Recommendation Report for Prior Notification of Work to Tree(s) in a Conservation Area

REF NO: **AW/354/14/TC**

LOCATION: 10 Tithe Barn Close
 Aldwick

PROPOSAL: Fell 1 No Ash tree & 1 No Tulip tree with the

TPO Plan

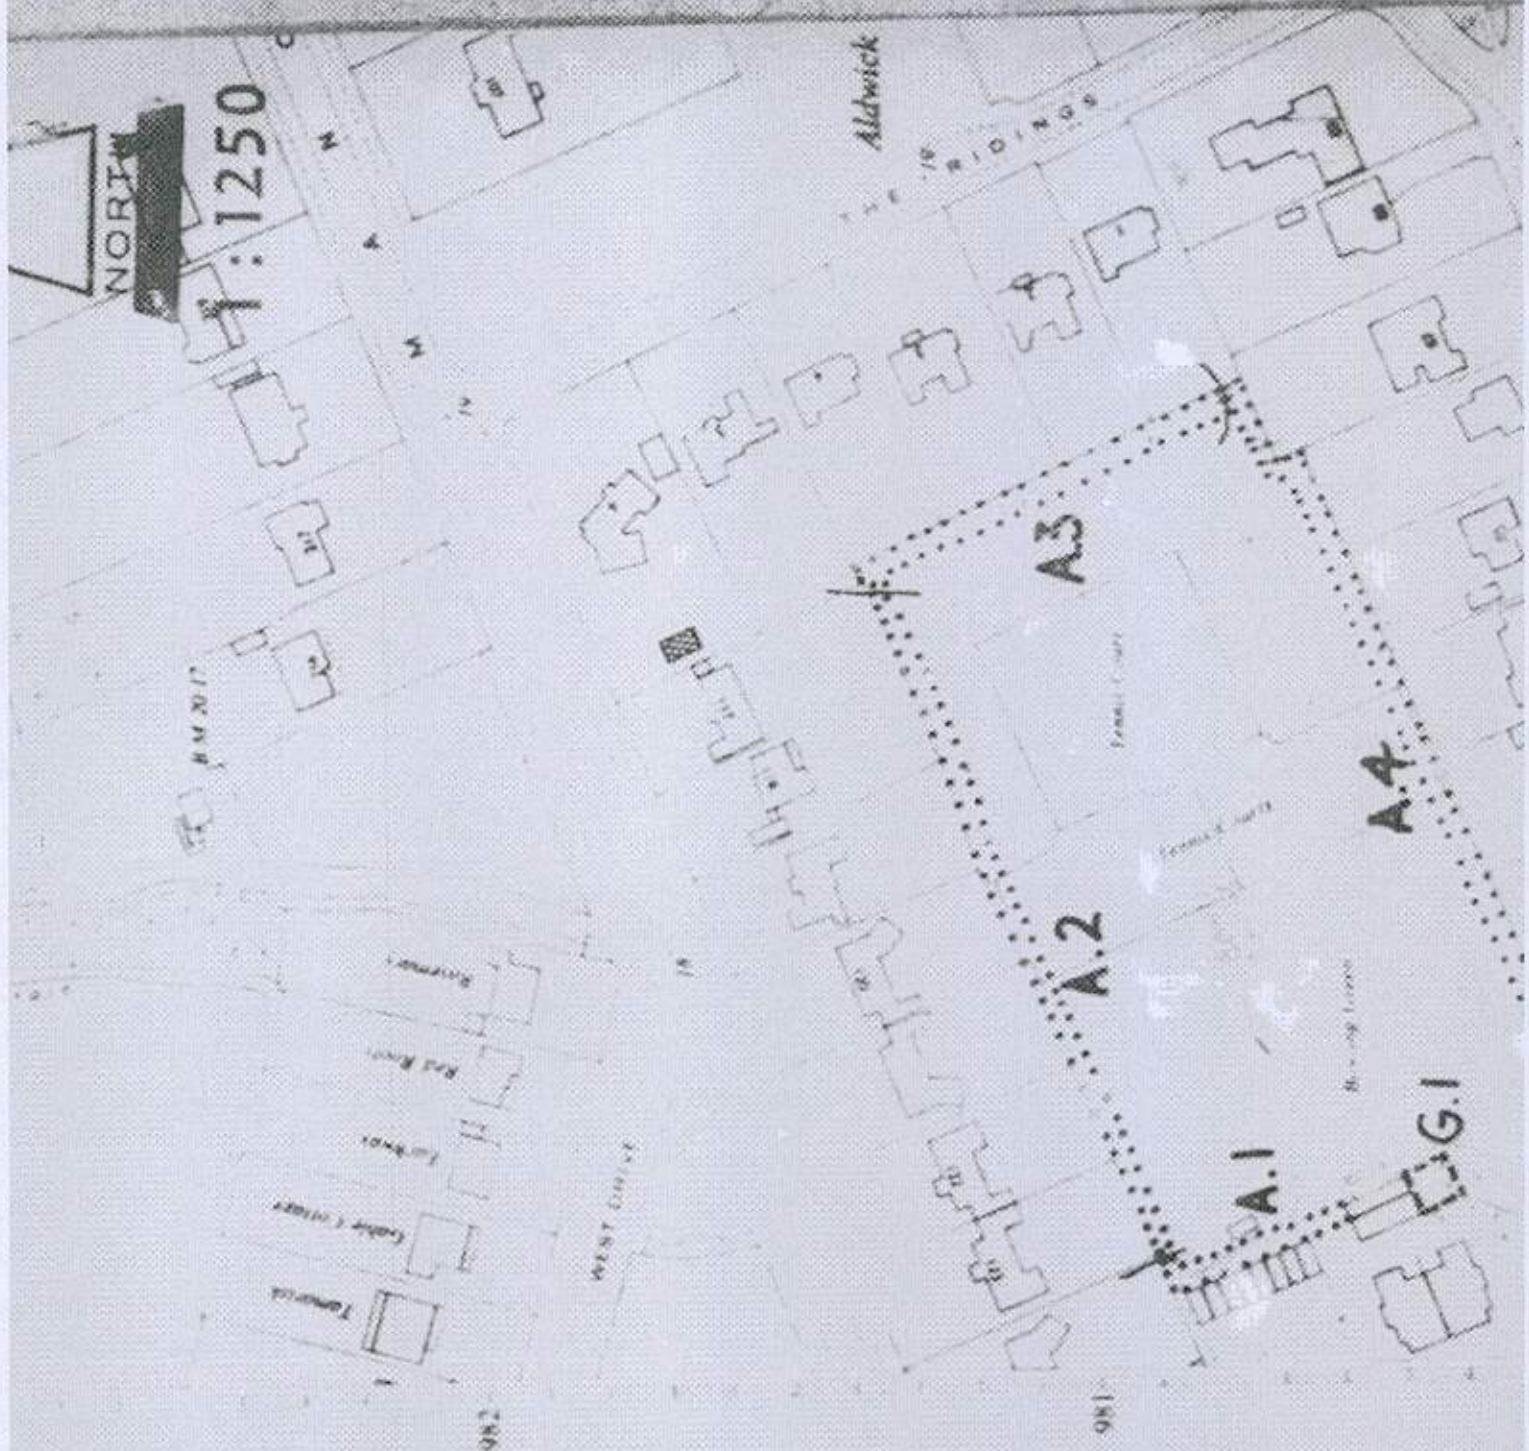
·The trees outlined in this application are situated along the southern boundary of 10 Tithe close.

·The applicant has requested the felling of T1 and T2, having cited 'shading', not being visible from the 'main highway' and the fact there are other trees in the garden to help the amenity value of the area.

·T1 and T2 are both in good to fair overall condition. It is also from a visual inspection that both T1 and T2 have both had reductions. These do appear to have completed to a standard that would meet the criteria set by the BS 3998 Section 7- Pruning and related work. This does mean a reasonable amount of mass from the crown. Also the position of the final cuts appears to have met the standards as set by the BS 3998: Section 7.2.5 figure 2.

·As these trees have a good retention span (as T1 and T2 are semi mature), and both trees are good overall condition, it would be my recommendation that both T1 and T2 are given TPO orders.

The applicant cites the 'shading' caused by the trees and that the trees are not visible from the 'main highway' as justification for the felling. A visual inspection of the trees was undertaken by the Council's Tree Officer and revealed that both trees are in good to fair condition and their protection would be justified through the implementation of a TPO.

Therefore, it is recommended that an objection is raised to the proposed works and a TPO is placed upon the trees the subject of this application.
